Appendix 4.2 C

KCC Water Services Department Meeting Notes

Notes from Pre-planning Technical Meeting between DOB&A and KCC WSD

Project:		Herbata Data Centre, Halverstown , Naas	
Project No.:		DOBA 2232	
Date:		11.04.2023 11.15 am	
Venue:		Microsoft Teams	
Attendees:			
	Kehinde Oluwatosin	KCC Planning	KO
	David Hall	KCC WSD	DH
	Donnachadh O’Brien	Donnachadh O’Brien & Associates	DOB
	Richard Kiernan	Donnachadh O’Brien & Associates	RK
	Martin Forte	Donnachadh O’Brien & Associates	MF
	David Bosonnet	Brady Shipman Martin (Landscaping)	DB

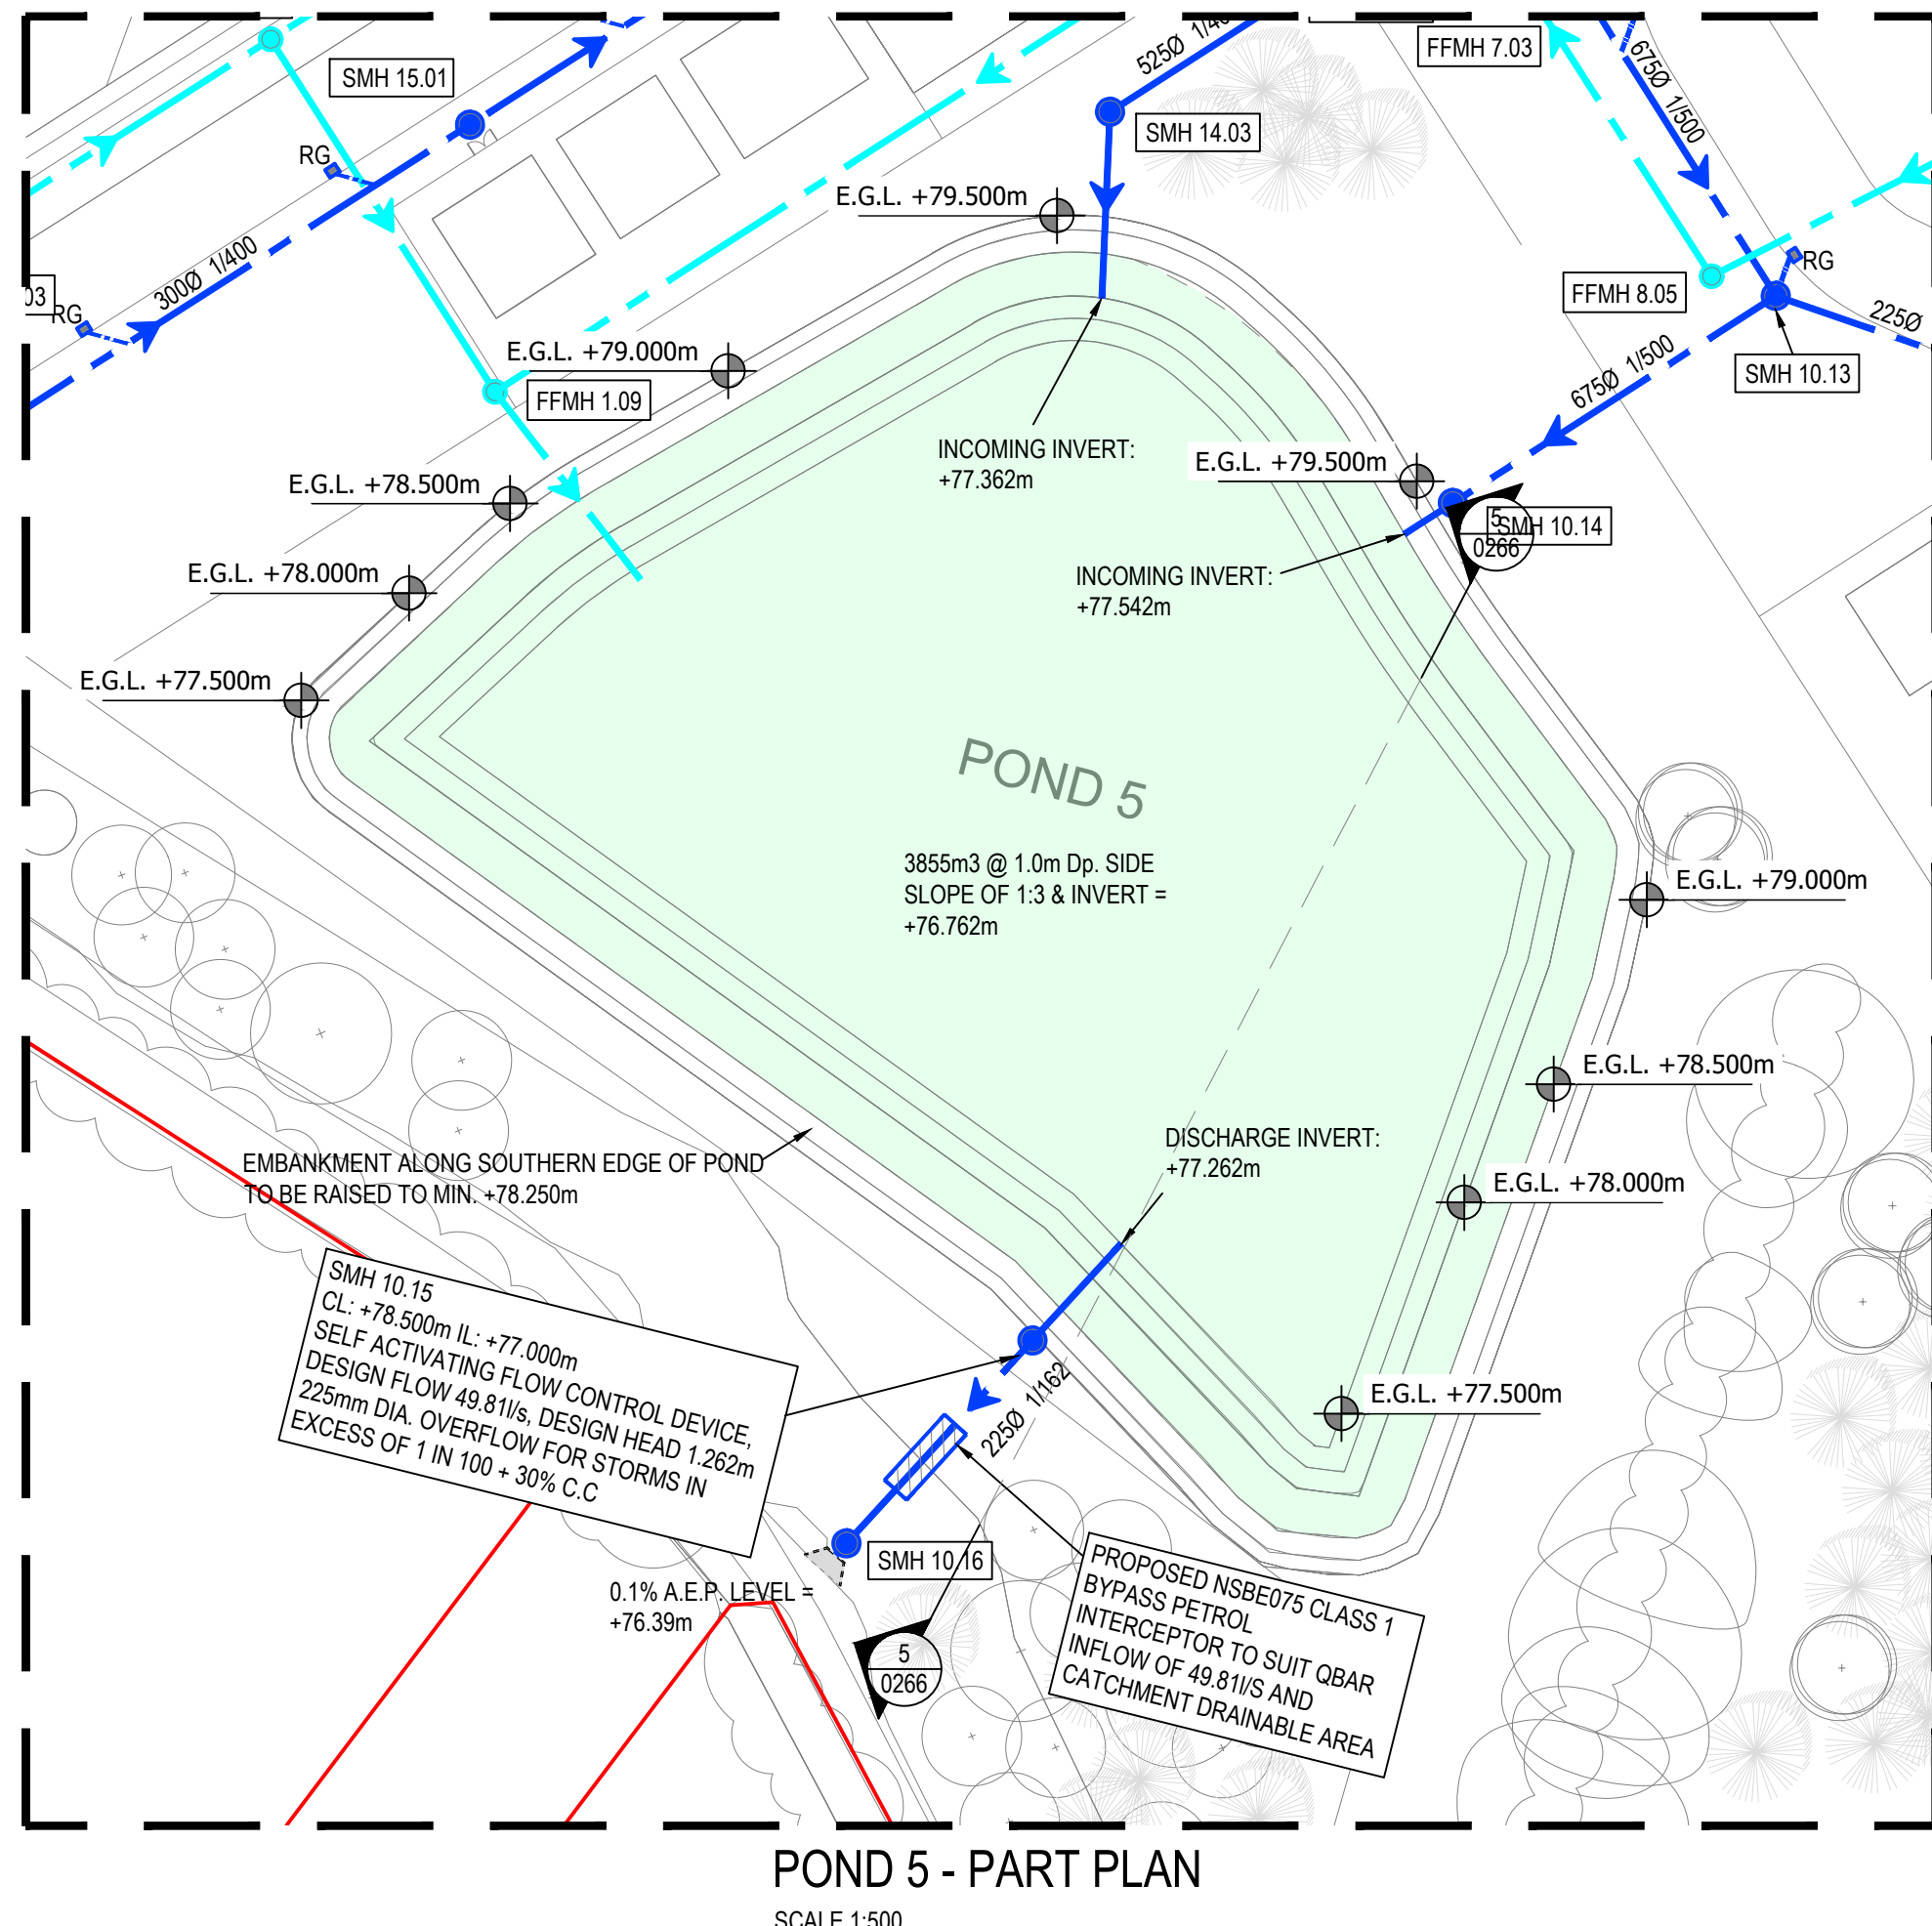
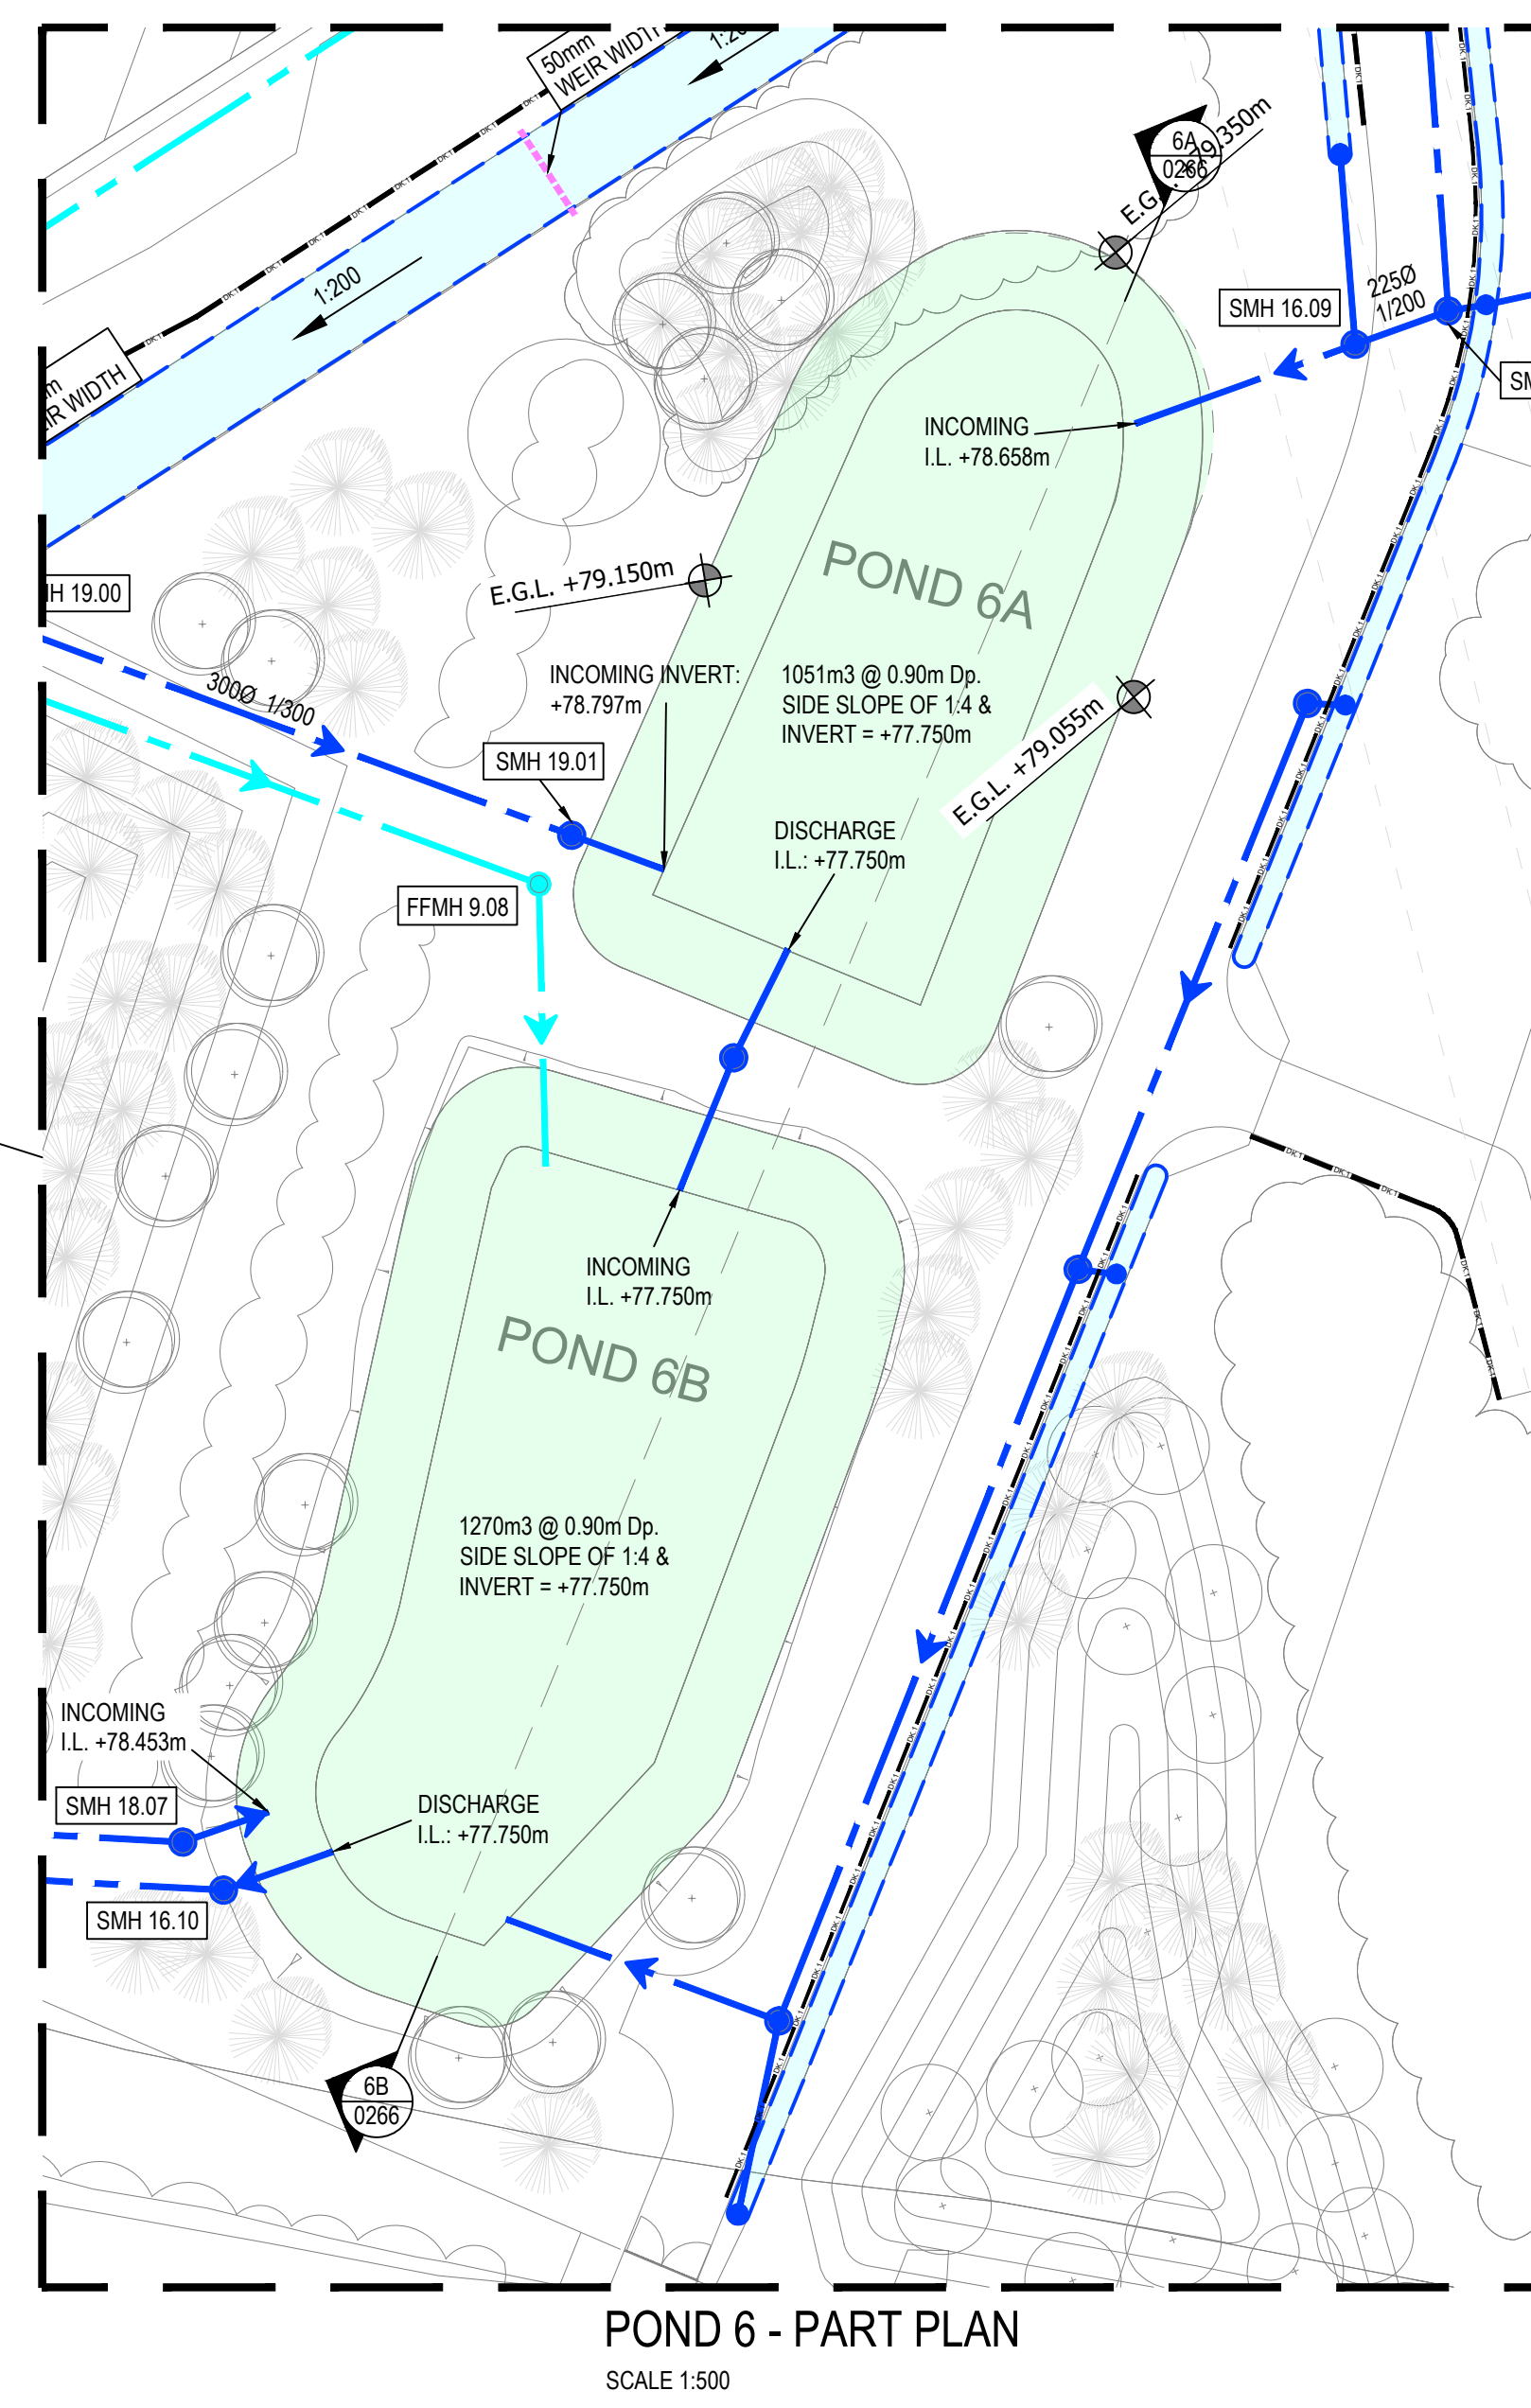
- Discharge of water direct to swales from internal road network by use of dropped kerbs. DOB showed a typical section noting this is being adapted. Roadside bioswales should also convey runoff where possible.
